Our ref: DOC21/1141687-29 Your ref: SSD-9094

#### Request for advice – Dalswinton Sand and Gravel Quarry – Muswellbrook LGA

I refer to your Major Projects Portal request on 22 December 2021 in which the Planning and Assessment Division (P&A) of the Department of Planning and Environment (the Department) requested Biodiversity and Conservation Division's (BCD) advice in relation to the Environmental Impact Statement (EIS) for the Dalswinton Sand and Gravel Quarry, located at 511 Dalswinton Road, Dalswinton (Lot 72 DP 1199484).

PROPOSED WATER MANAGEMENT PLAN

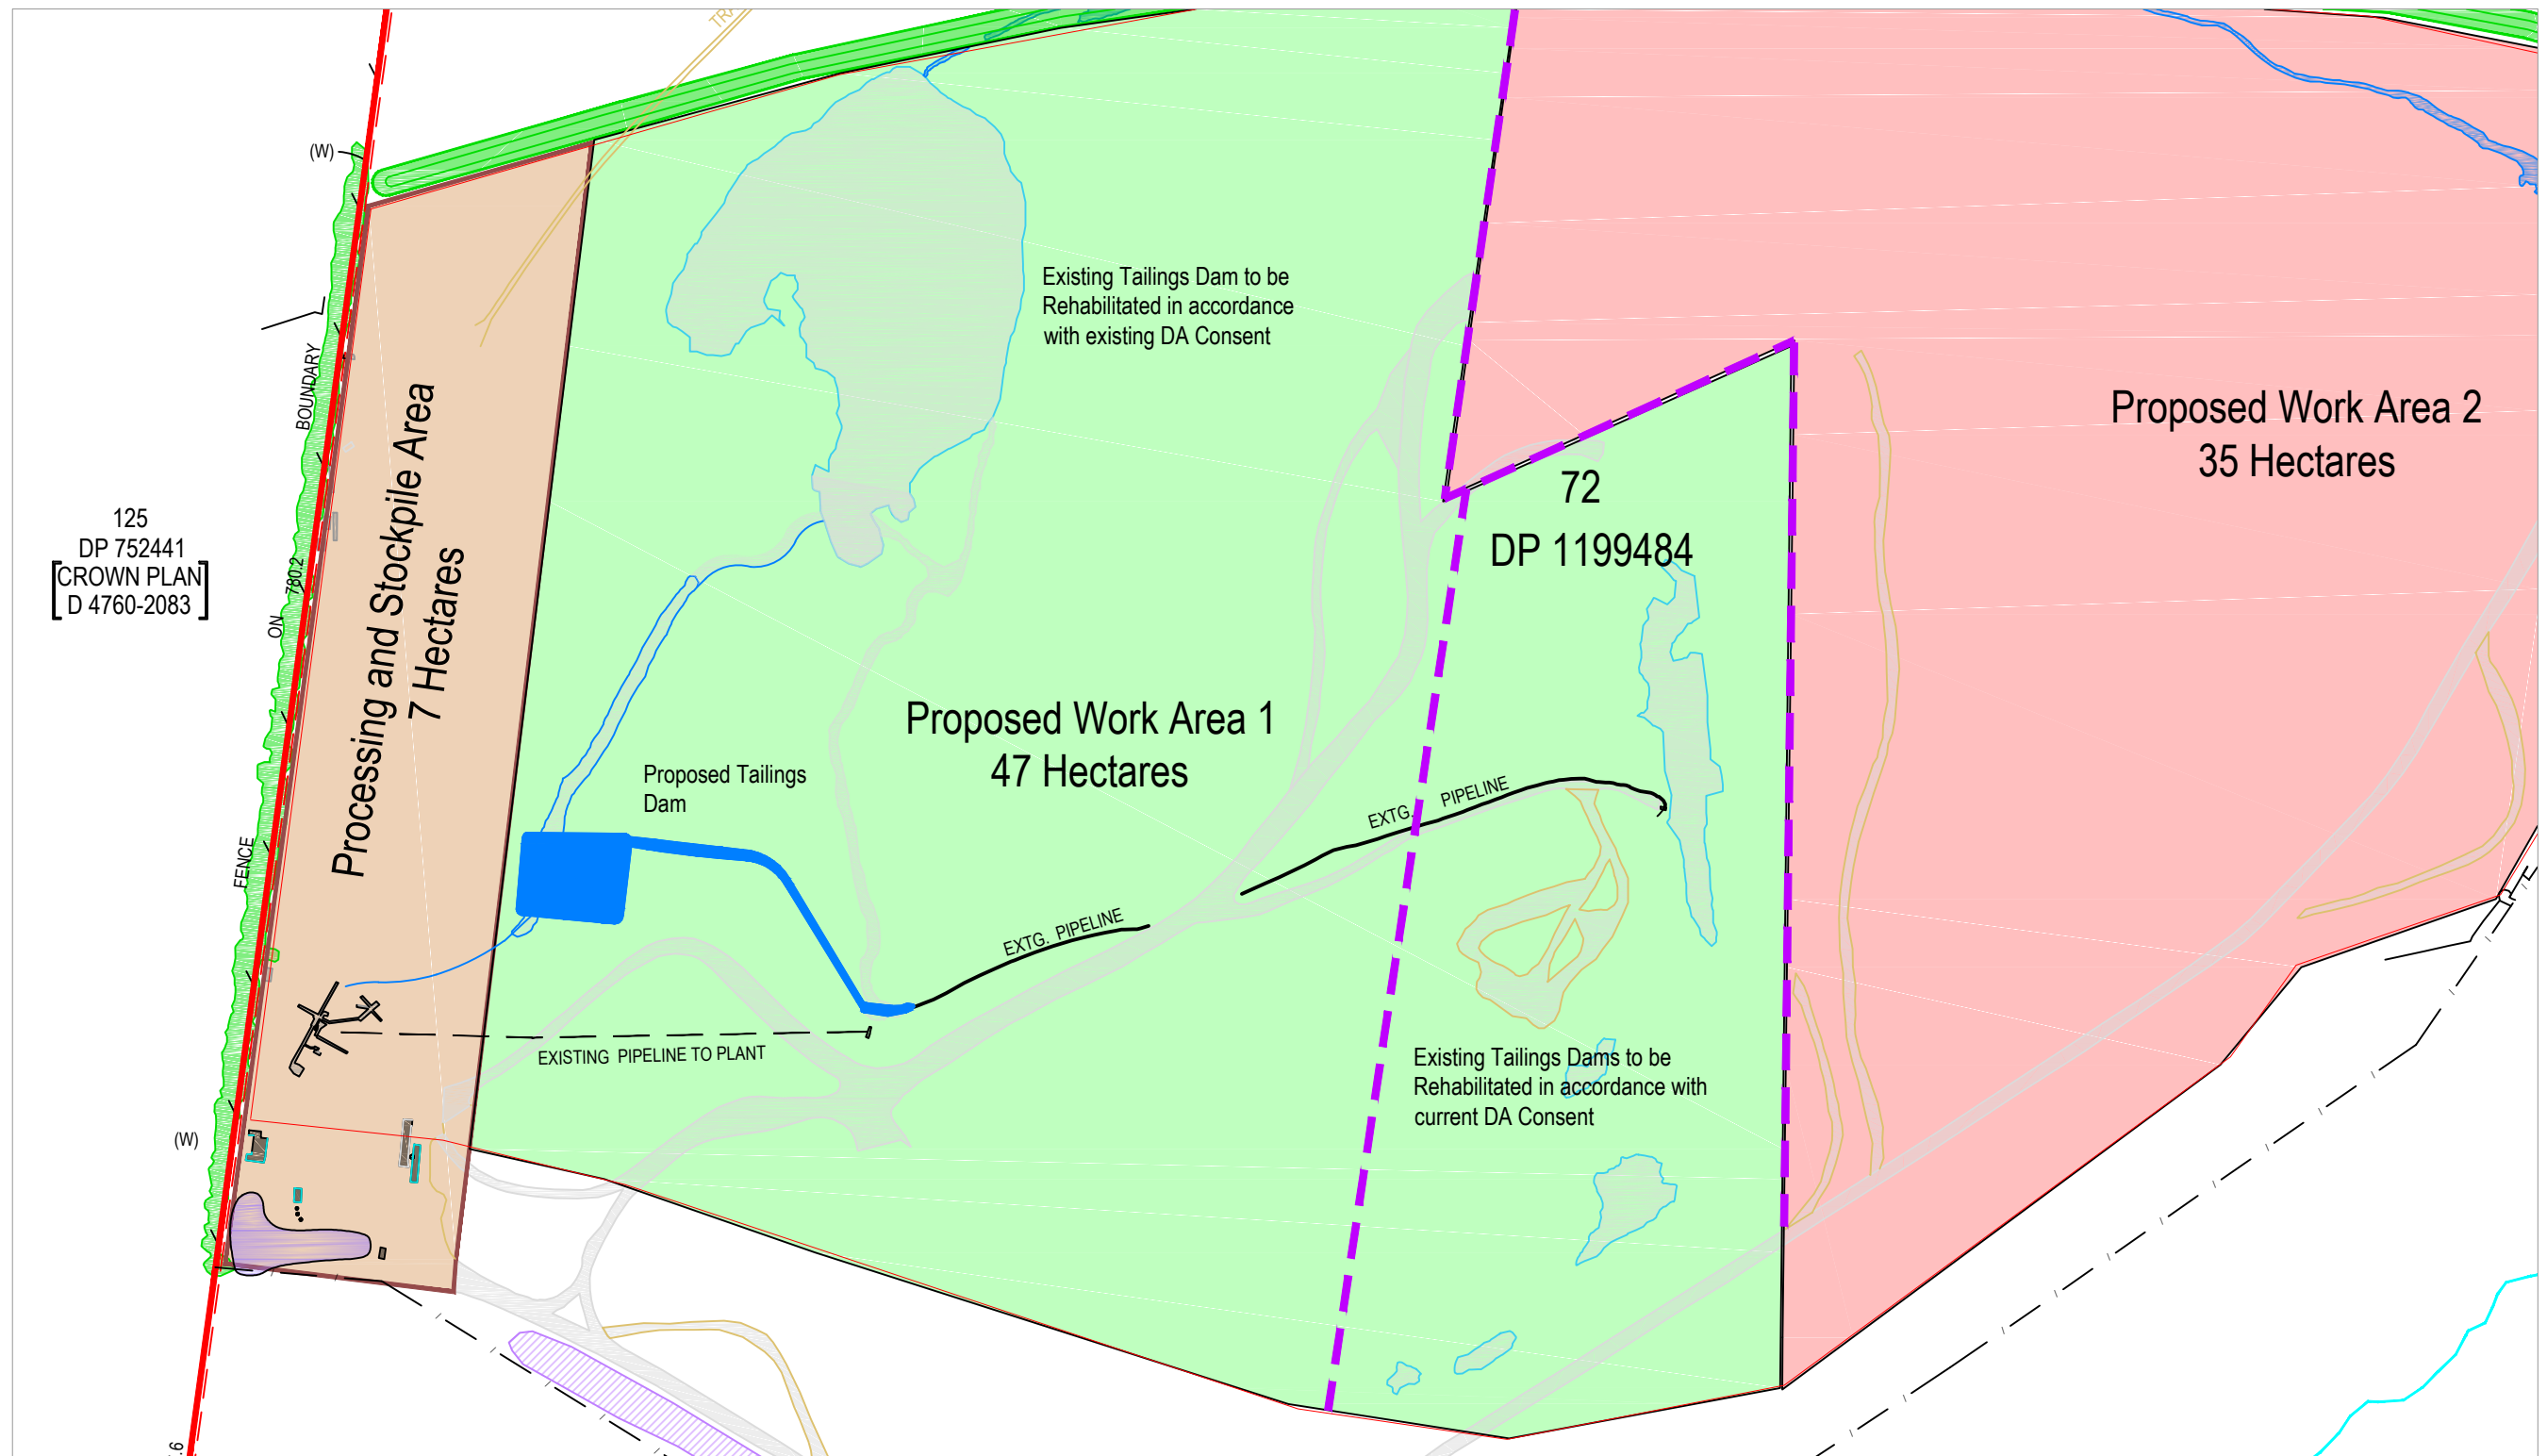
The EIS Figure 13 and the Water Management Plan Appendix 0 show the northern dam to be removed and a smaller tailings dam to be built to the south. The Surface Water management plan, Appendix V prepared by Umwelt dated Nov 2020 in figure 3.3 indicates that water management will remain very similar to the existing facilities and the Northern dam will be retained as the main storage and treatment facility.

The inconsistent water management documents should be reviewed and the EIS updated to show consistent water management methods and dam locations.
